National Highways Planning Response (NHPR 24-02)
Formal Recommendation to an Application for Planning Permission

Council's Reference: AL/11/24/OUT

Location: Land East of Westergate, Westergate

National Highways Ref: NH/24/05130

2019 Baseline Traffic Flows
AM Peak

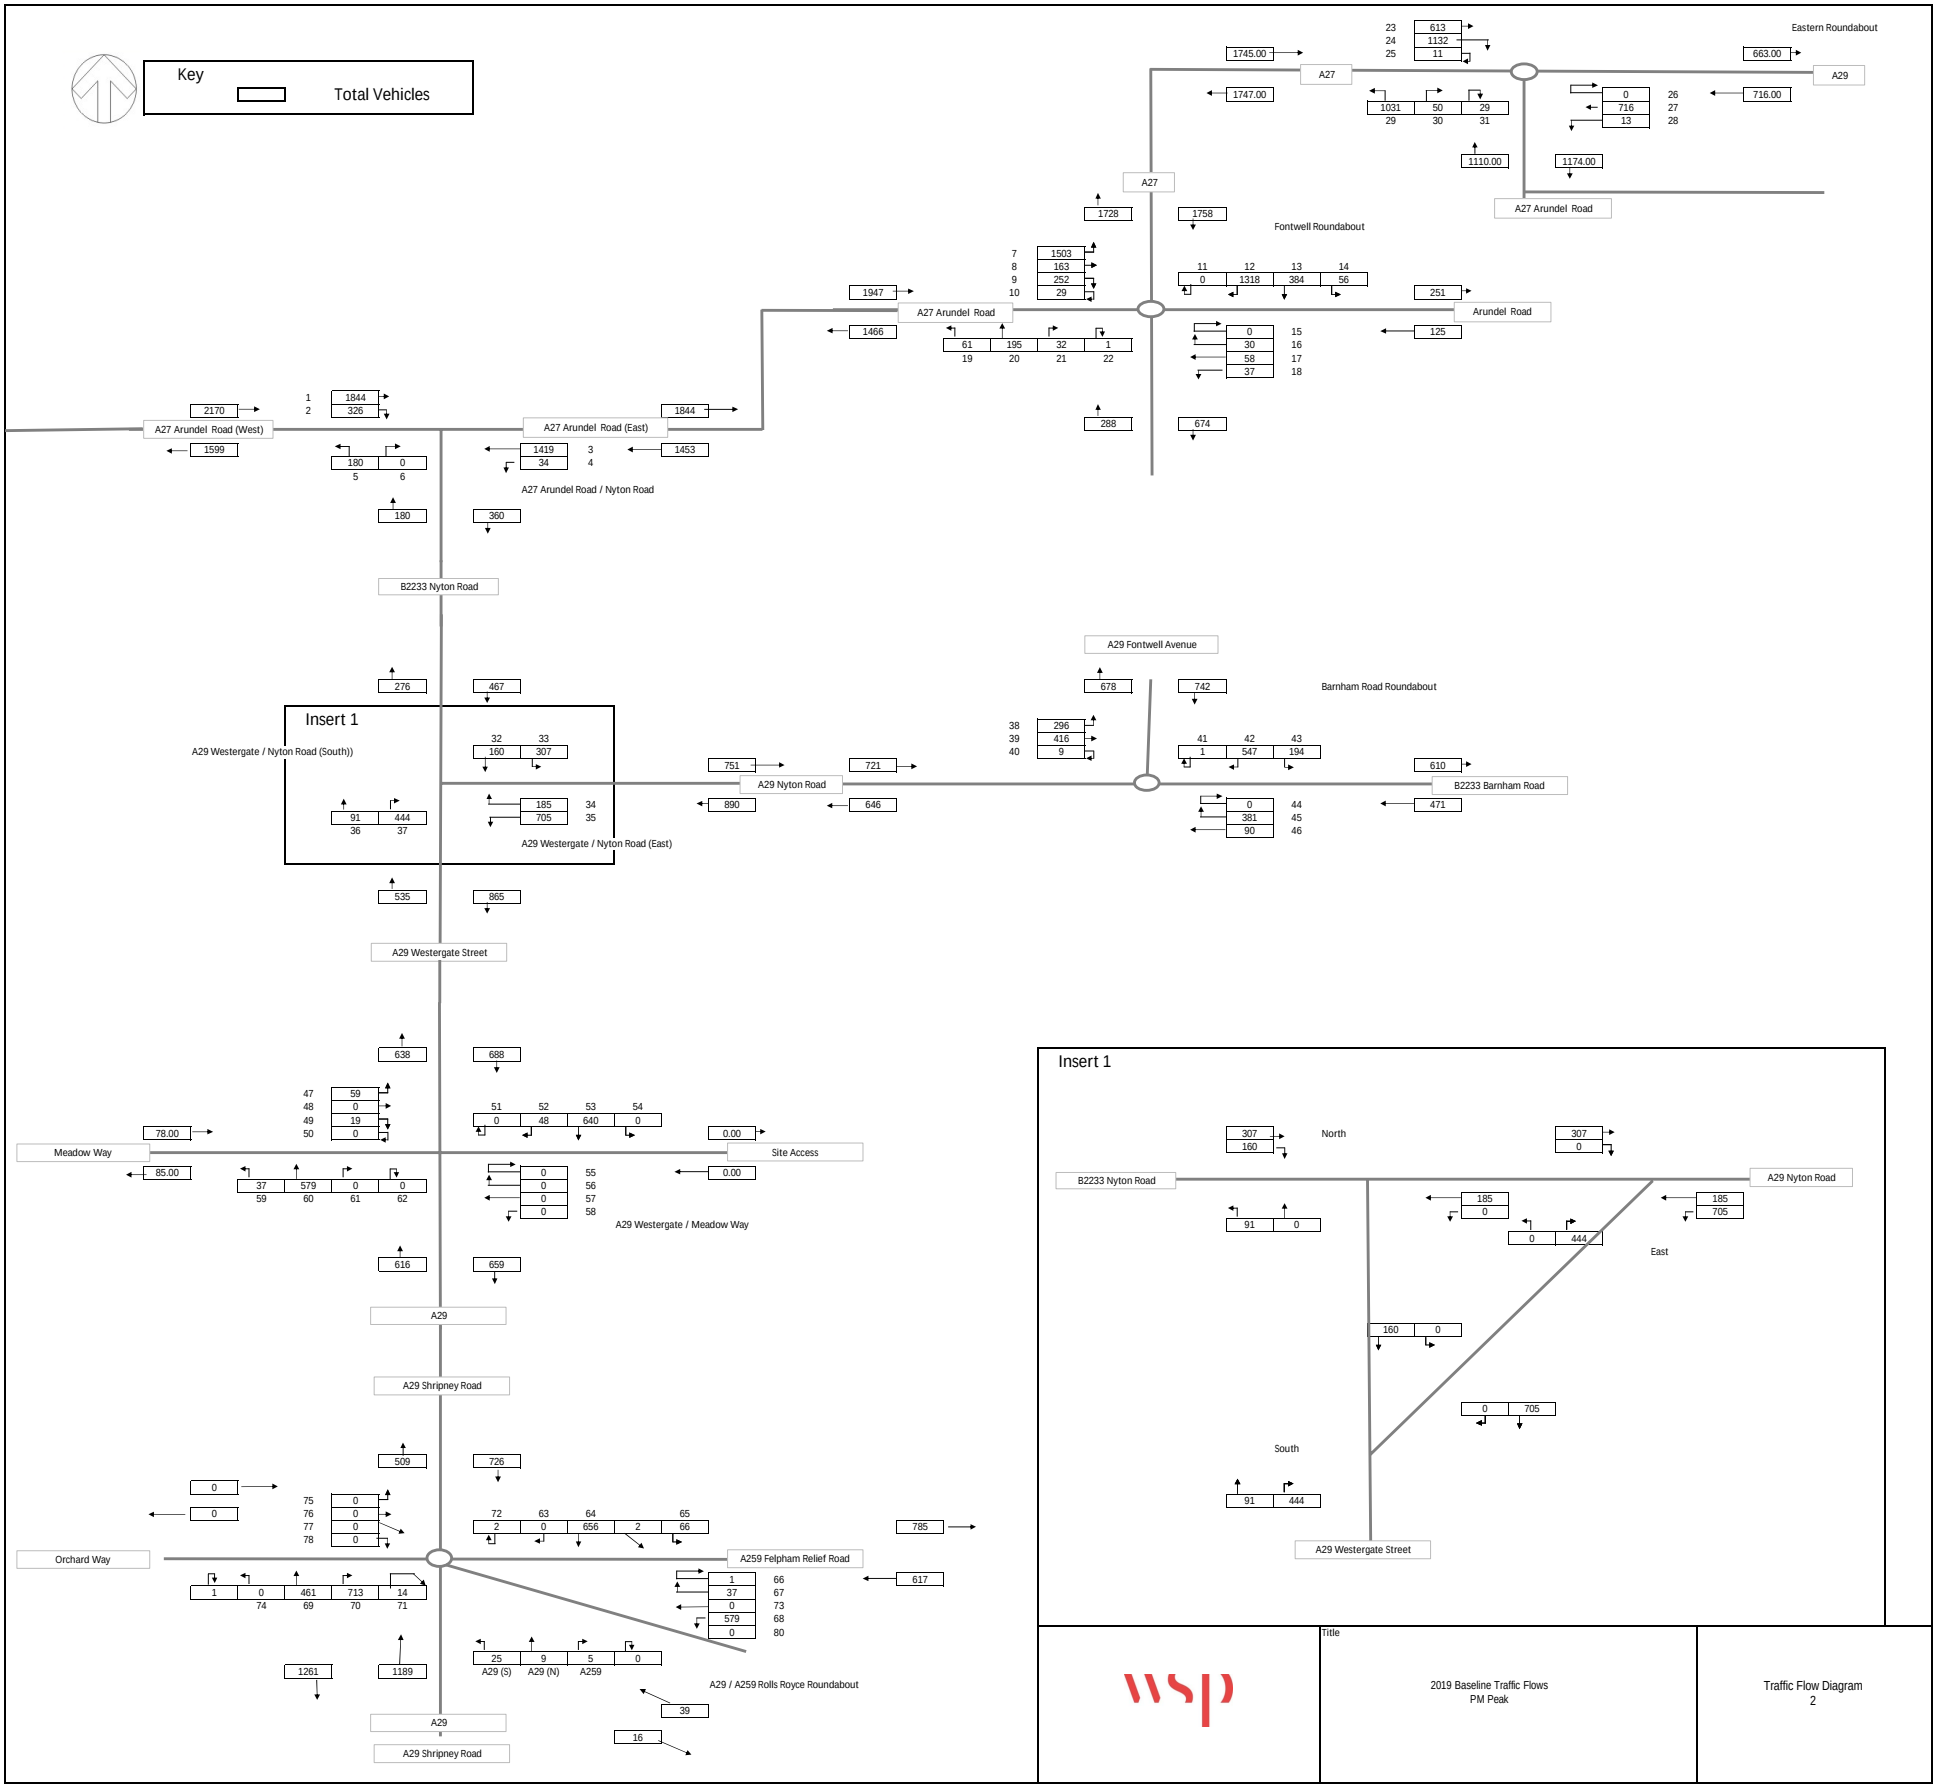
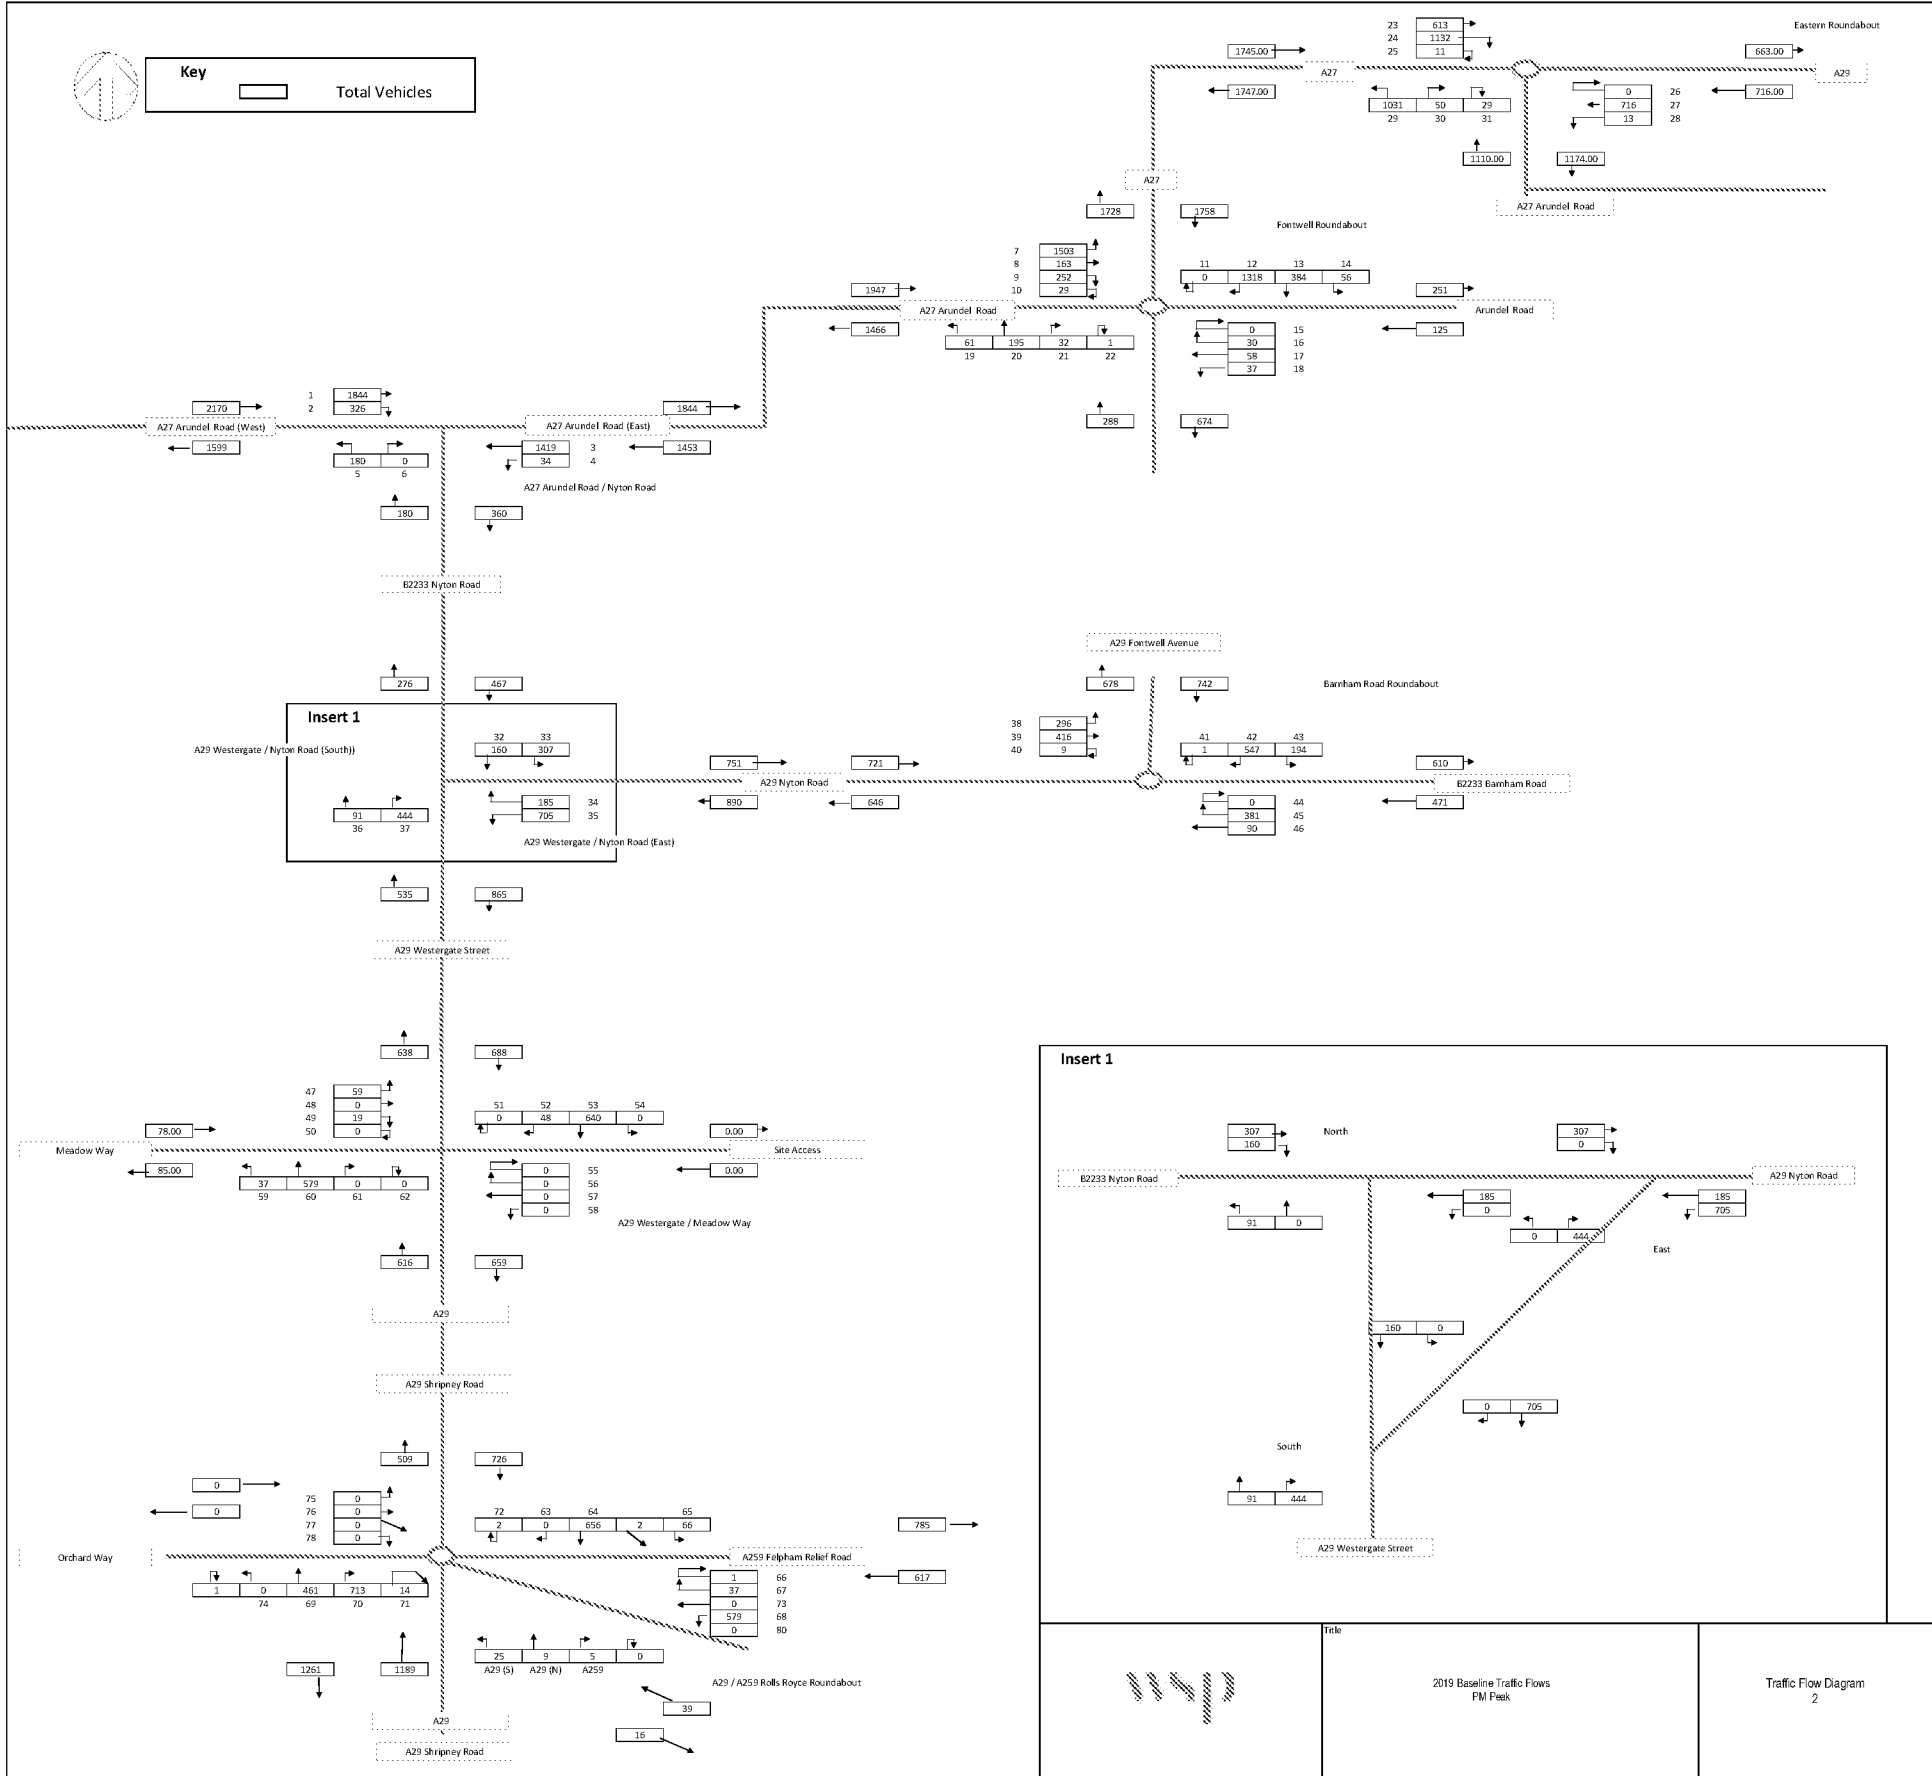
- 2019 Baseline Traffic Flows AM/PM – **how was this derived from CATM, please provide details**
- 2031 Do Minimum Traffic Flows AM/PM – derived from CATM, confirmed to be consistent with BEW Parcel SC1 TA

Figure 7-1 - A27/ A29 Eastern Roundabout Improvement Scheme

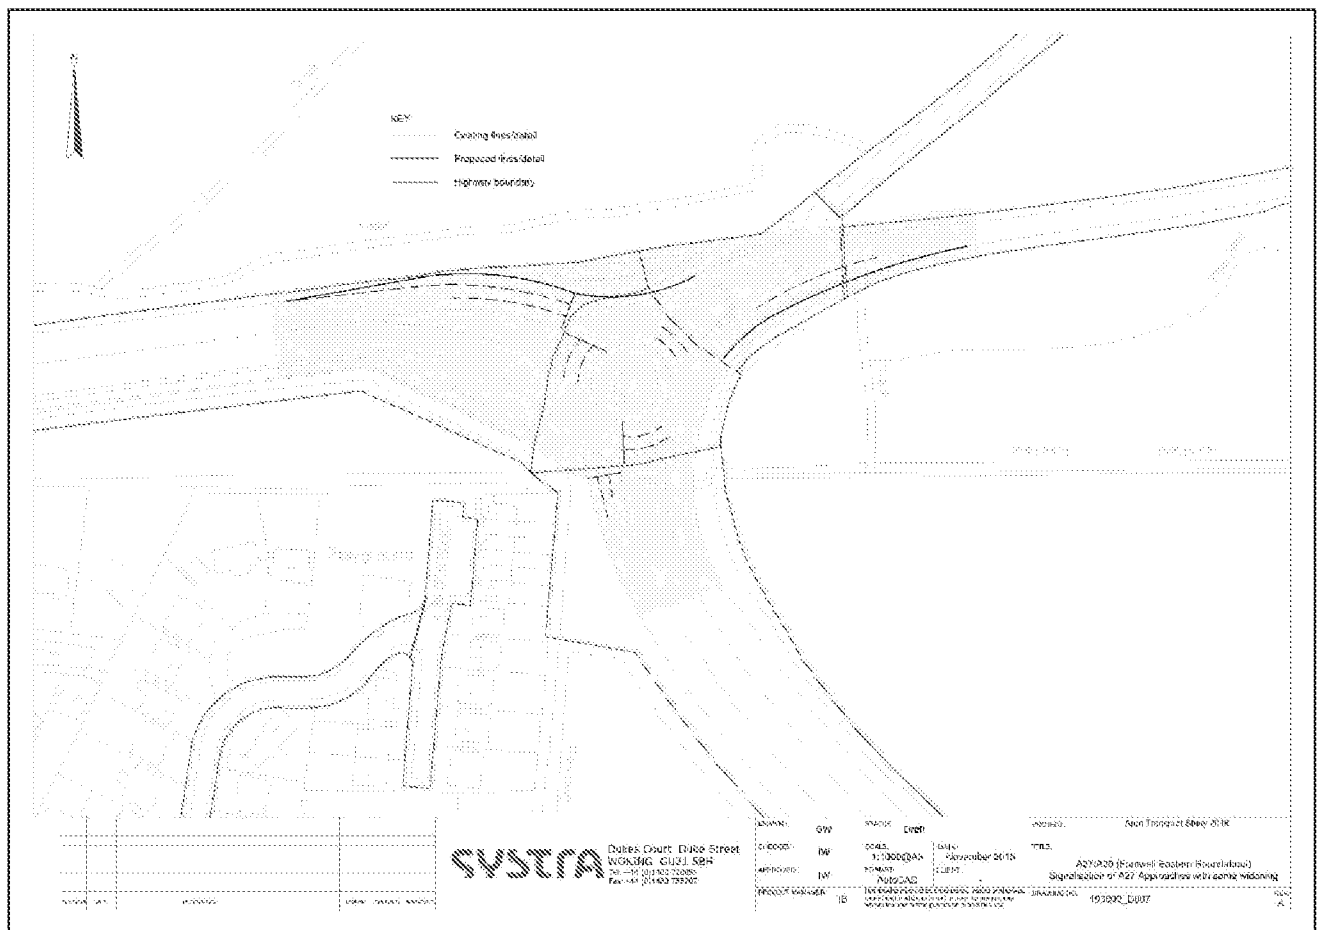
- Geometry has been reviewed and we note the following:
 - **The geometry figures are not clear in the submitted PDF; hence clarifications are needed**
 - **Assessment appears to have been undertaken based on existing geometry, the report text noted that at para. 7.2.4 that the 2017 Enterprise Bognor Regis Transport Review (EBRTR) mitigation has been considered 'only where the existing layout is forecast to operate close to capacity or over capacity' therefore clarification is required**

Figure 7-2 - A27/ A29 Western Roundabout Improvement Scheme

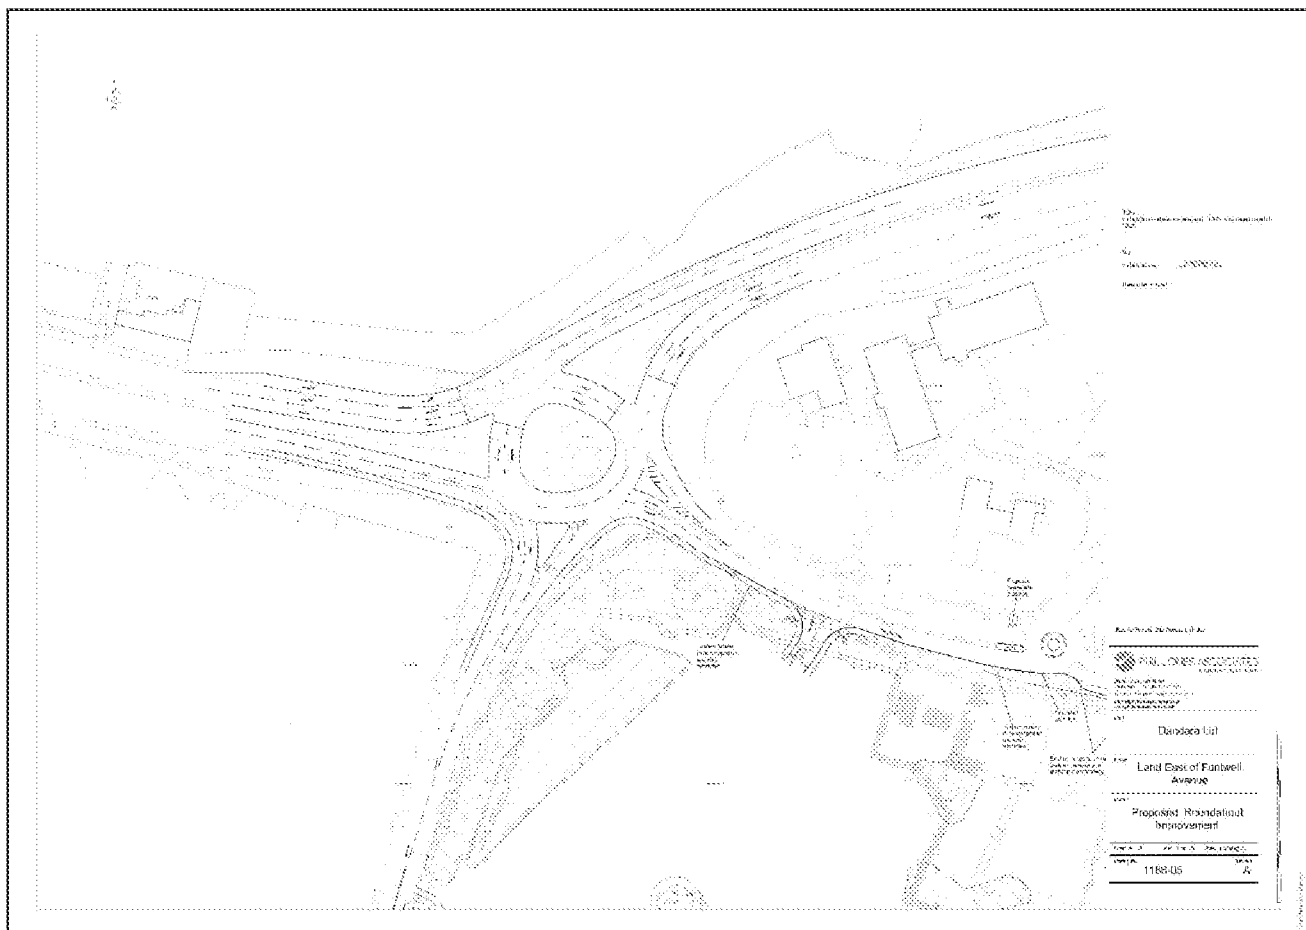
At the time of the TA being prepared the Fontwell West Roundabout had recently been signalised on the north and west arms and this is reflected in the future year

assessment. **We note that Appendix C of the TA contains the LinSig output, however we cannot see the 2019 Baseline Junctions assessment, and this should be clarified.** The Fontwell West Roundabout junction assessment has been undertaken using LinSig and we note the following:

- **A27 (north): lane widths are input as 5m, please review as we observe these lanes to be in the order of 4.5m, lane lengths are acceptable, radius to be reviewed**

- **Arundel Road: lane widths are input as 3m, please review, based on aerial imagery lanes appear wider, we acknowledge parked cars, lane lengths are not reasonable, lane 2/1 is input as 5 PCUs, this appears to be 3 PCU, radius to be reviewed**

- **A29 Fontwell Avenue: lane widths are input as 3.75m, please review, based on aerial imagery lanes appear narrower, lane lengths are not reasonable, lane 3/1 is input as 5 PCUs, this appears to be 1 PCU, radius to be reviewed**

- **A27 (west): lane widths are input as 4m, please review as we observe these lanes to be in the order of 3.75, lane lengths should be 60 PCU for 4/1 and 4/2 and 10 PCU for 4/3, radius to be reviewed**

- **Circulatory carriageway: radii to be reviewed, input values are too large**
 - **Please provide CAD drawing demonstrating measurement of all the geometric parameters**
